Subject: Consultation Response 2021/93644 Low Farm, Wakefield Road, Flockton, Huddersfield, WF4 4BB
Date: 23 June 2022 16:51:56

2021/93644 Low Farm, Wakefield Road, Flockton, Huddersfield, WF4 4BB Erection and operation of grid-connected solar photovoltaic farm to supply up to 49.9MW, with ancillary infrastructure and landscaping and biodiversity enhancements Low Farm, Wakefield Road, Flockton, Huddersfield, WF4 4BB

Drawing Infomation	
Scale	1:2500 @ A0
Stage	ISSUED FOR REVIEW
Drawing Name	Overall Layout
Drawing Number	B001
Designed By	Samuel Hogan
Sheet 1 of 1

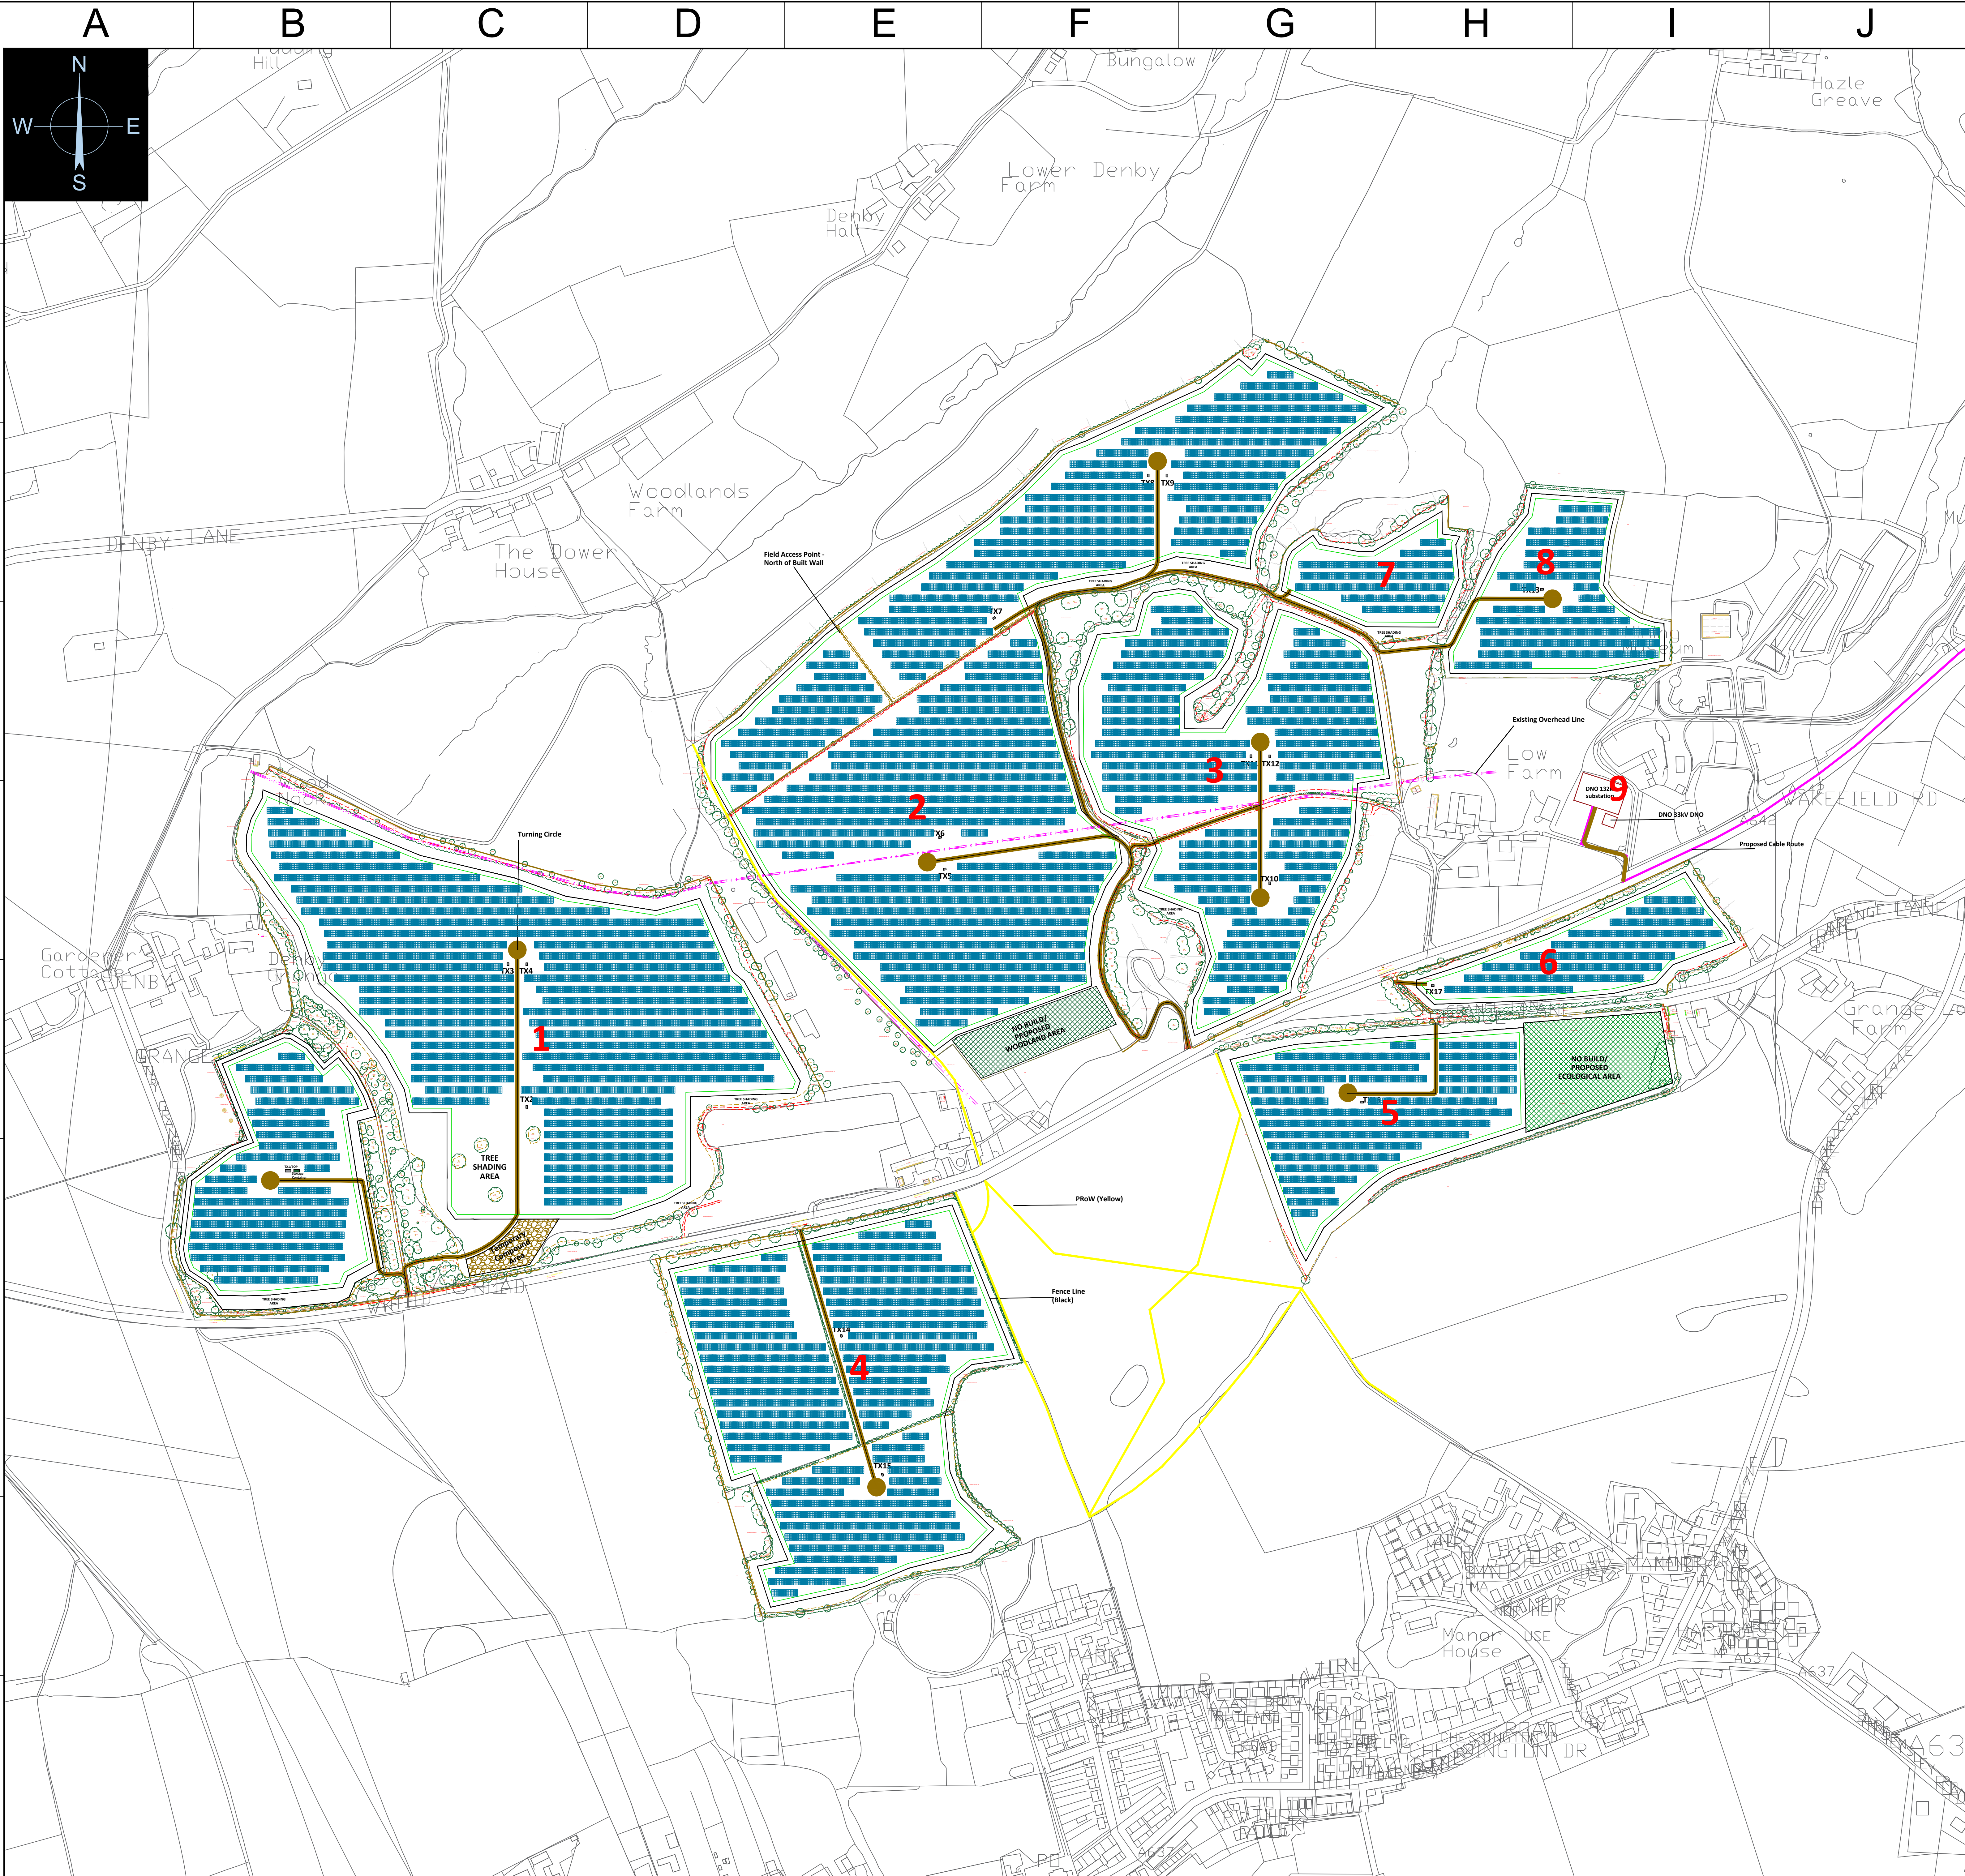
To the north-east of the site the known cropmark MWY614 is shown in spectacular detail as a concentric ditched circular enclosure with internal divisions (anomaly 2Ea-Ed). Some of the large pits visible on the geophysical survey appear to be gate posts or a gate structure. Two long "antennae" like ditches extend to the south-west of the enclosure. These may be to create an entrance, to frame a view of a distant landmark, for defence or have an agricultural function.

A less spectacular anomaly at 2Da is suggested to be a building and may relate to post medieval use of the site.

The footings of the PV panels, cabling and trackways may cause damage to these features and other remains in their wider setting.

The WYAAS recommend that areas 2D and 2E are subject to archaeological evaluation to determine the impact that the solar farm will have on the buried archaeological remains identified. This information can then be used to design footings, cabling routes and trackways in these parts of the site.

- Should significant remains be present then the applicant should consider the use of ground bearing supports for the PV panels rather than posts. This is to preserve archaeological remains in situ.
- Further archaeological works including excavation and/or an archaeological watching brief may be necessary during the construction of the solar farm. An appropriate level of public participation in this work should also be secured.
- Depending on the results of any excavation information on the site's archaeological
